DESCRIPTION OF REQUEST: DRB FINAL SIGNOFF OF SITE PLAN FOR BUILDING PERMIT

**RE: Paradise View Universal Apartments  
lot 12A Paradise Hills Investment Properties  
Site plan for building permit  
EPC final signoff**

Rio Grande Engineering requests DRB approval of the enclosed site plan for building permit. This plan was approved with conditions by the EPC on August 12, 2016. An appeal of this approval was denied by the approval upheld by the city council on November 7, 2016 (AC-16-13). We have revised the plans to address the conditions. Below is the list of conditions with the resulting corrective actions taken underlined.

ENGINEER'S SEAL	PARADISE VIEW UNIVERSAL APARTMENTS	DRAWN BY WCUJ
	SITE PLAN FOR BUILDING PERMIT	DATE 4-02-08
	<i>Rio Grande Engineering</i>	2511-SP50-3-25-06X
	1608 CENTRAL AVENUE SE SUITE 201 ALBUQUERQUE, NM 87106 (505) 972-9850	SHEET # 1 OF 5
DAVID SOULE P.E. #14522		JOB # 2511

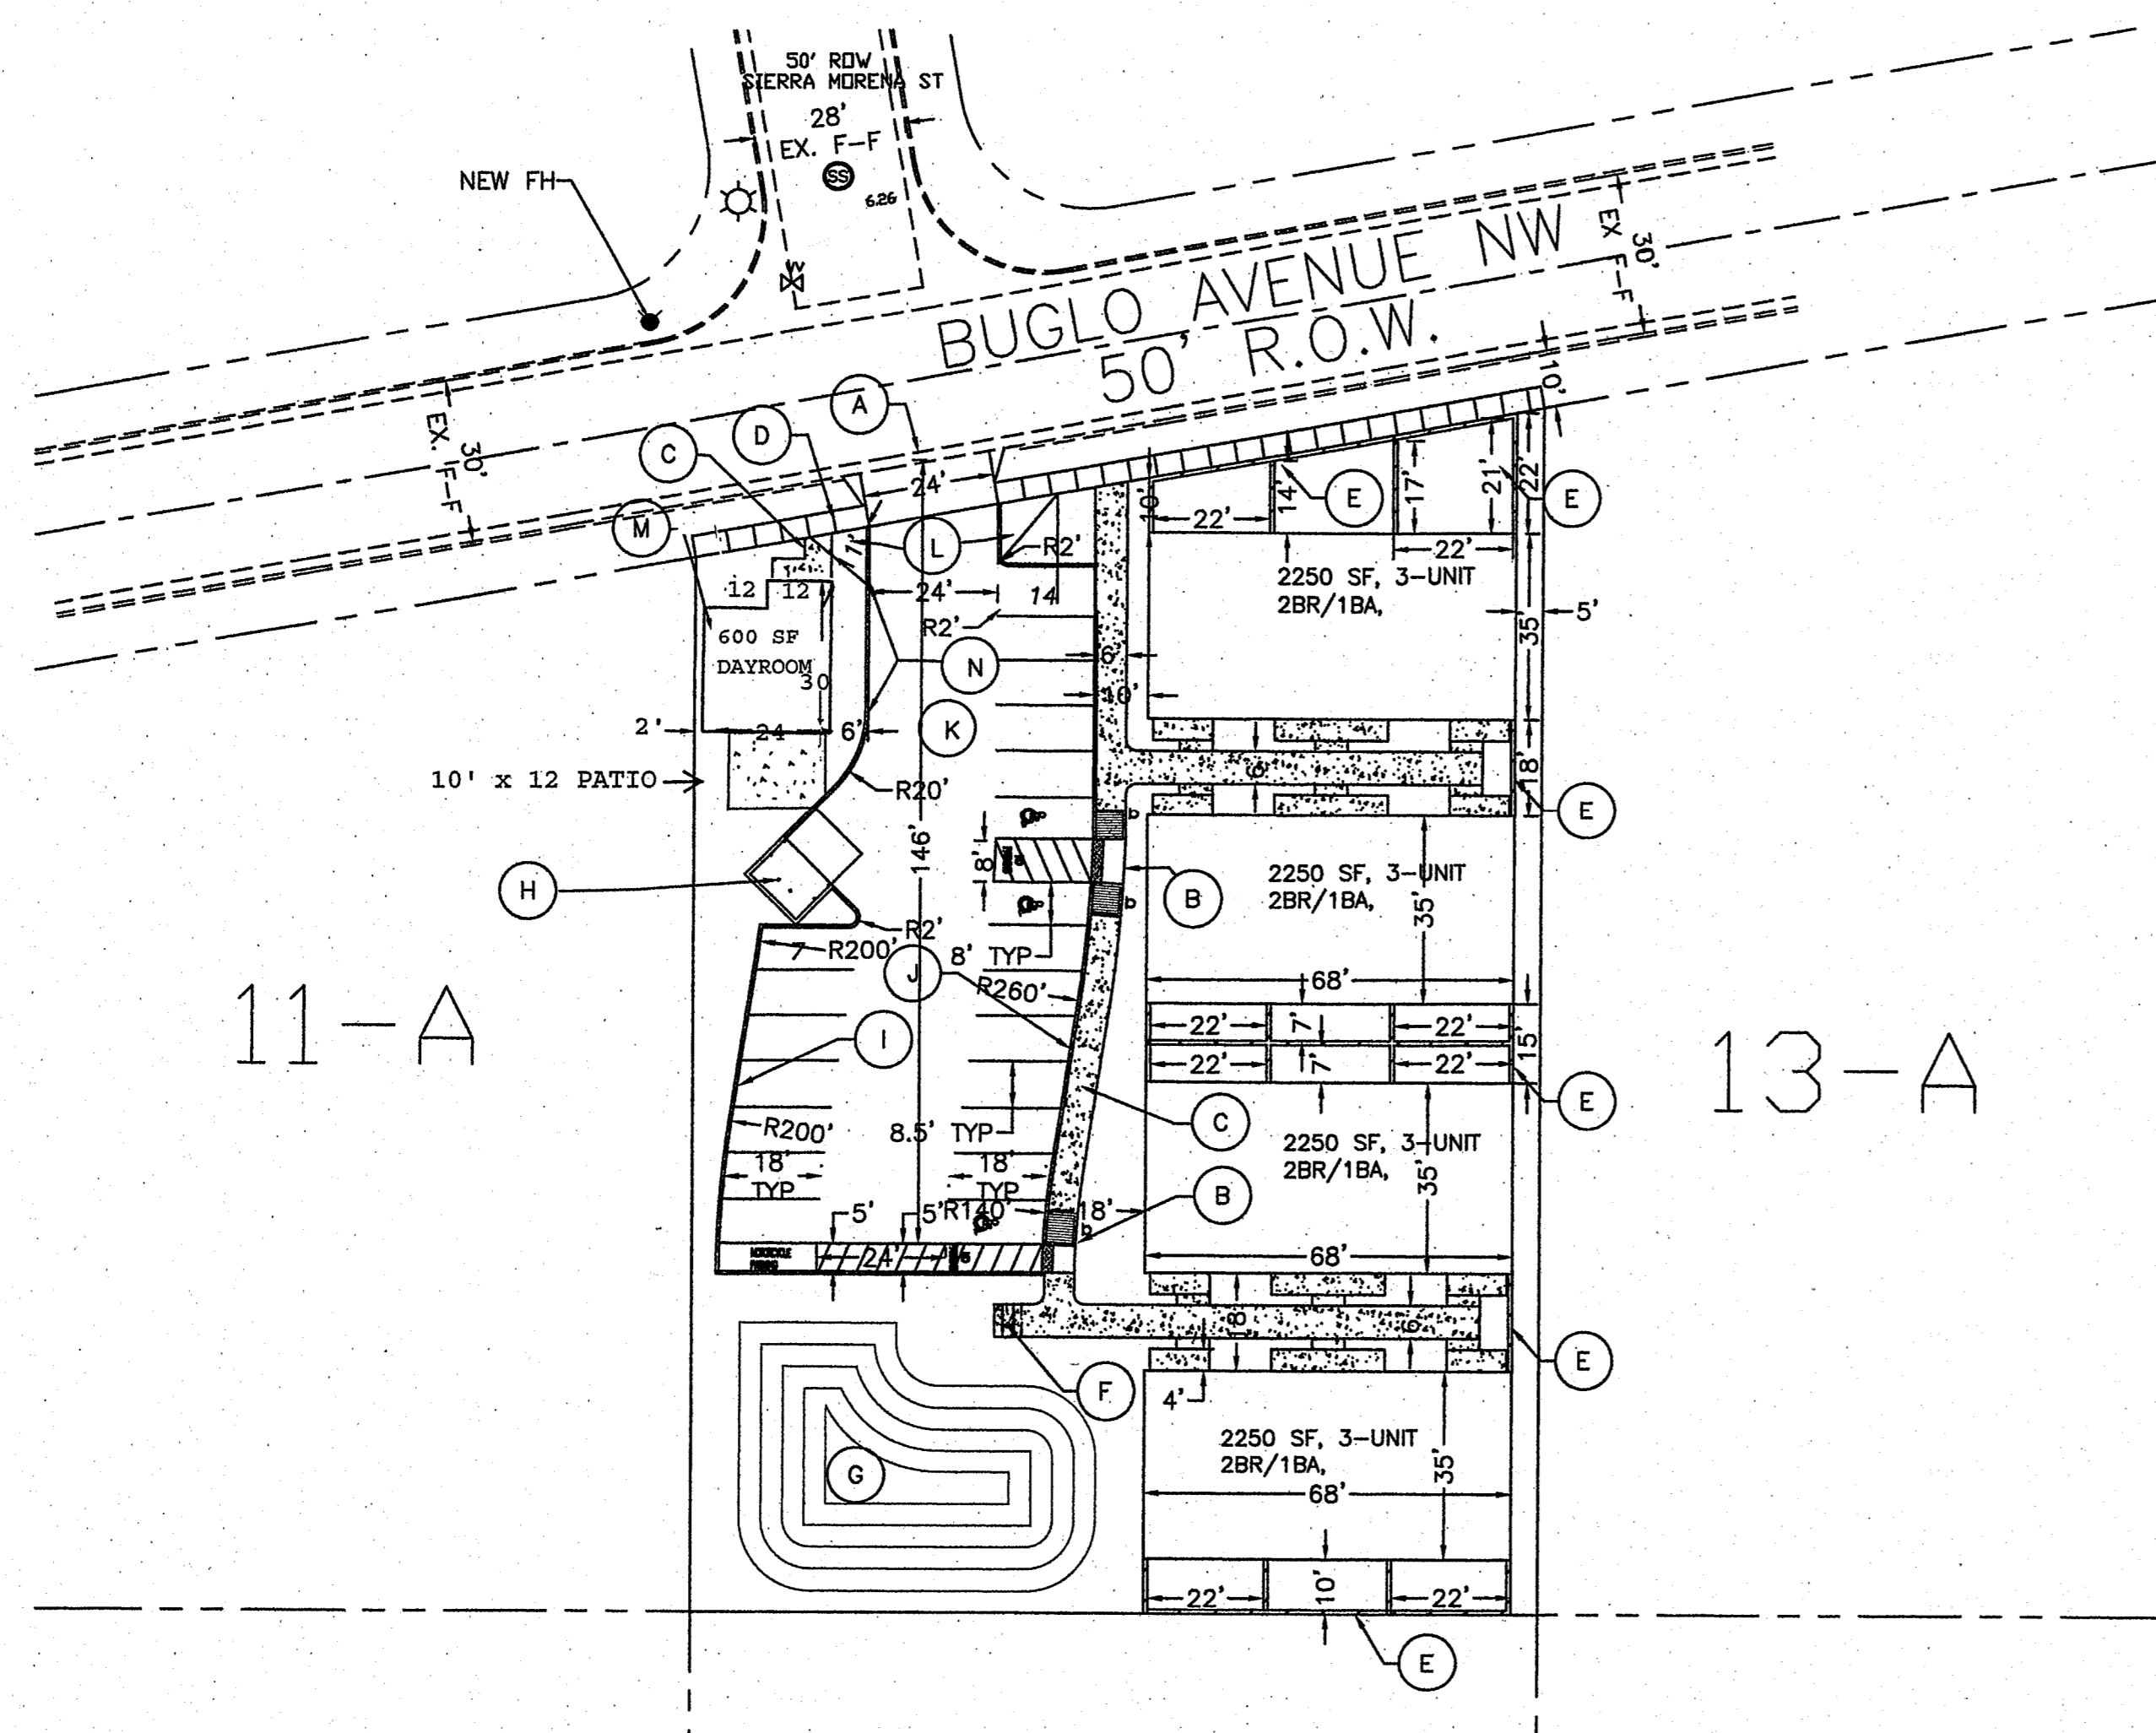
- A. Identify the right of way width, medians, curb cuts, and street widths on Buglo Ave. and cross streets north of project area.

- B. The ADA accessible parking sign must have the required language per 66-7-352.4C NMSA 1978 **"Violators Are Subject to a Fine and/or Towing."** Please call out detail and location of HC signs.

- C. Show all drive aisle widths and radii.

- D. Per DPM, a 6 ft. wide ADA accessible pedestrian pathway is required from the public sidewalk to the building entrances. Please clearly show this pathway and provide details.

- E. Per DPM, a 6 ft. wide ADA accessible pedestrian pathway is required from the HC parking stall access aisles to the building entrances. Please clearly show this pathway and provide details. Provide striped access isle across drive pad from Dayroom HC parking to access isle leading to residential units.

- F. All sidewalks along streets should be placed at the property line.

- G. Provide a min 6" or max 8" high concrete barrier curb or other acceptable barrier between landscaping and parking areas and/or drive aisles. Please call out detail and location of barrier curb.

- I. It is not apparent what type of pavement surface is being proposed. A hard driving surface will be required as part of this proposed project for parking area and drive aisles.

- J. Please provide a sight distance exhibit (see the *Development Process Manual, Chapter 23, Section 3*). Please provide this detail at the entrance/exit on Buglo Ave.

- K. Please add the following note to the clear sight triangle: "Landscaping and signage will not interfere with clear sight requirements. Therefore, signs, walls, trees, and shrubbery between 3 and 8 feet tall (as measured from the gutter pan) will not be acceptable in this area."

- L. Please add a note on the plan stating "All improvements located in the Right of Way must be included on the work order."

- M. Developer is responsible for permanent improvements to the transportation facilities adjacent to the proposed development site plan, as required by the Development Review Board (DRB).

We have added to the plan

We have added as note 12

We have labeled

We have labeled and referenced city standard details

We have added

We show sidewalks at property line

we have labeled as key note J

We have labeled as key note K

We have labeled as key note L

We have added note 13

We have added note 14

We have added note 15

PARADISE VIEW UNIVERSAL APARTMENTS LANDSCAPE PLAN

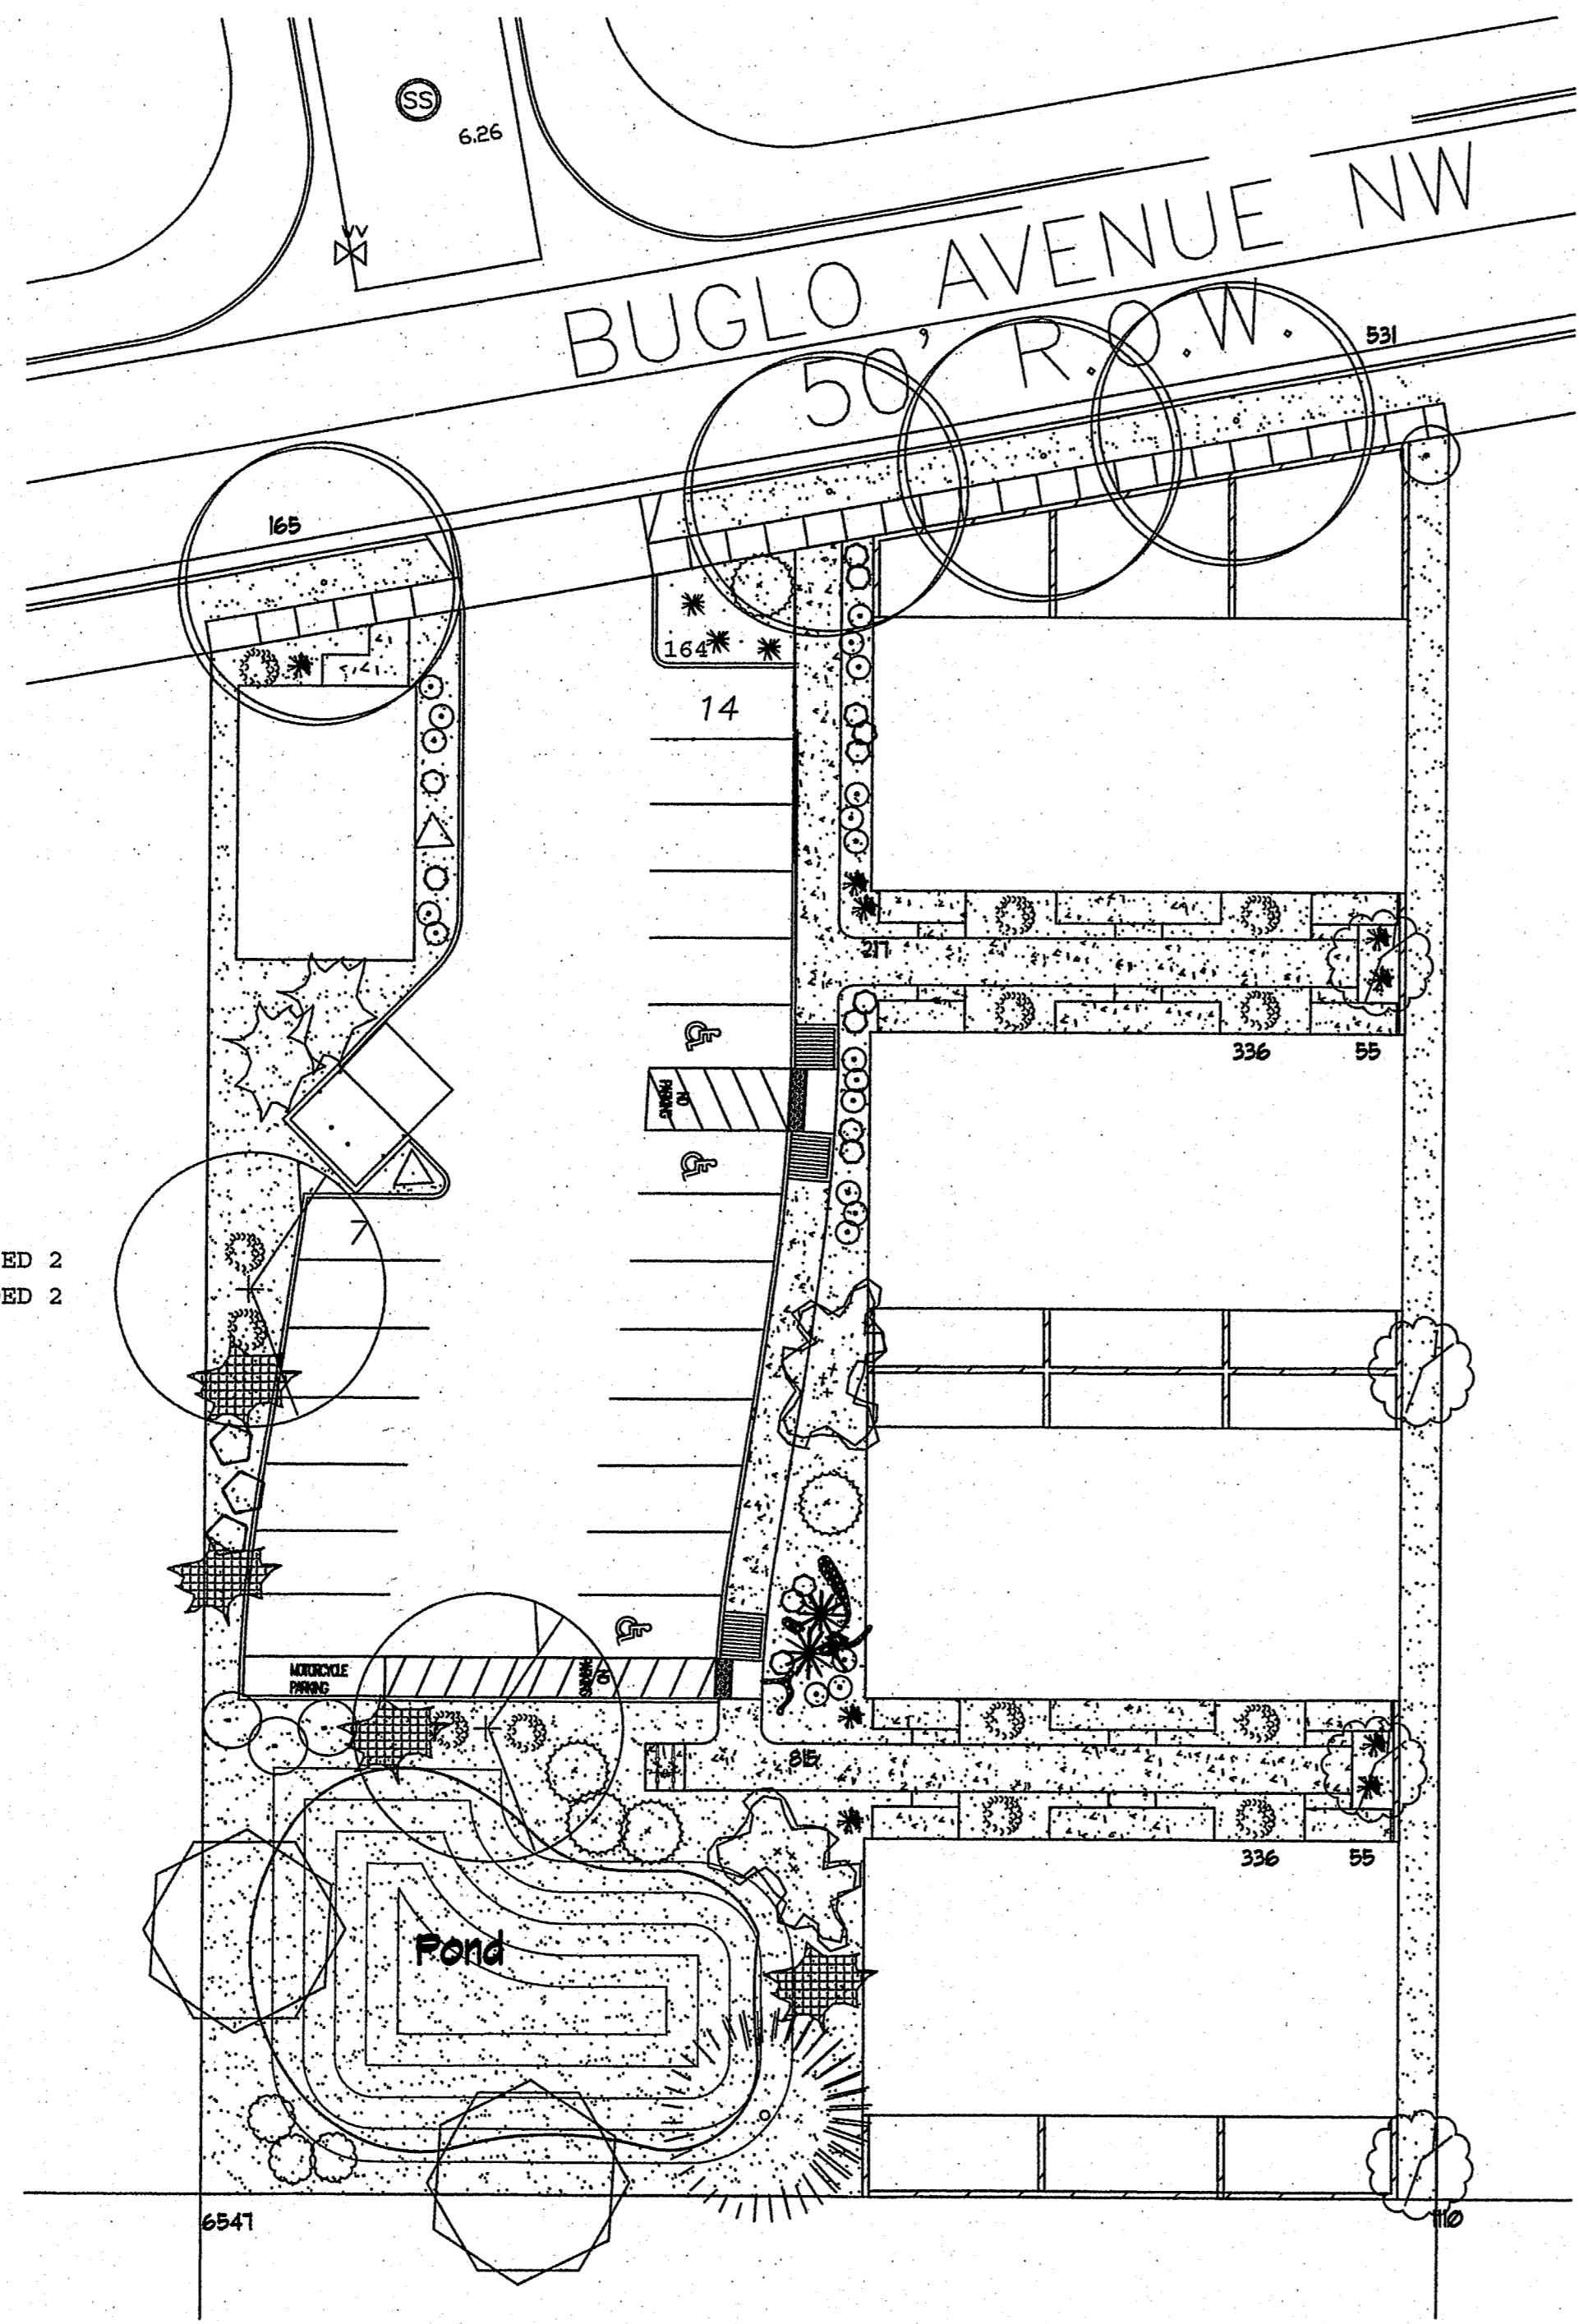
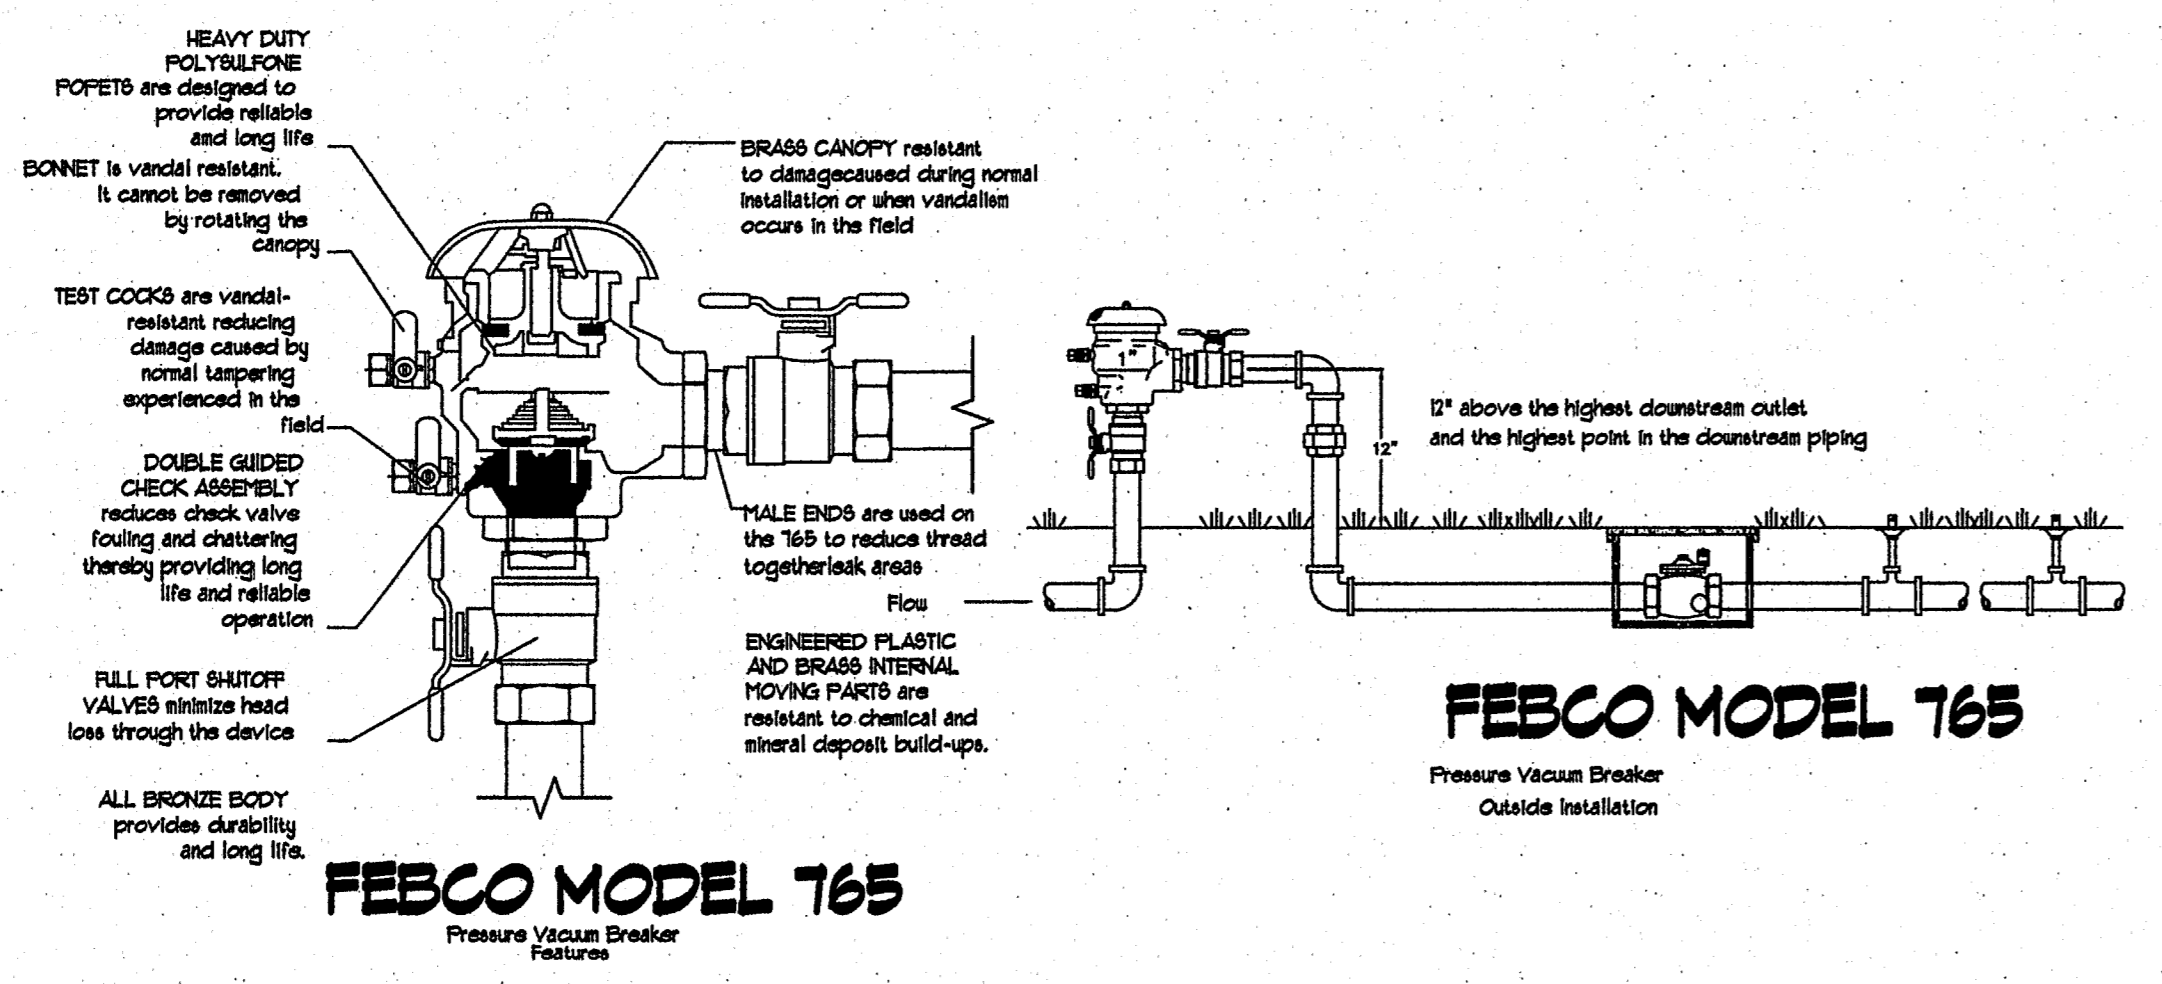
5. Clearer, more detailed notes shall be added to the landscape plan.  
We have added an updated landscape plan
6. Notes need to be added referencing the restrictions on signage to maximum of 25 square feet per building facade and no freestanding signage are permitted  
We show the only signage and added note 17 to site plan
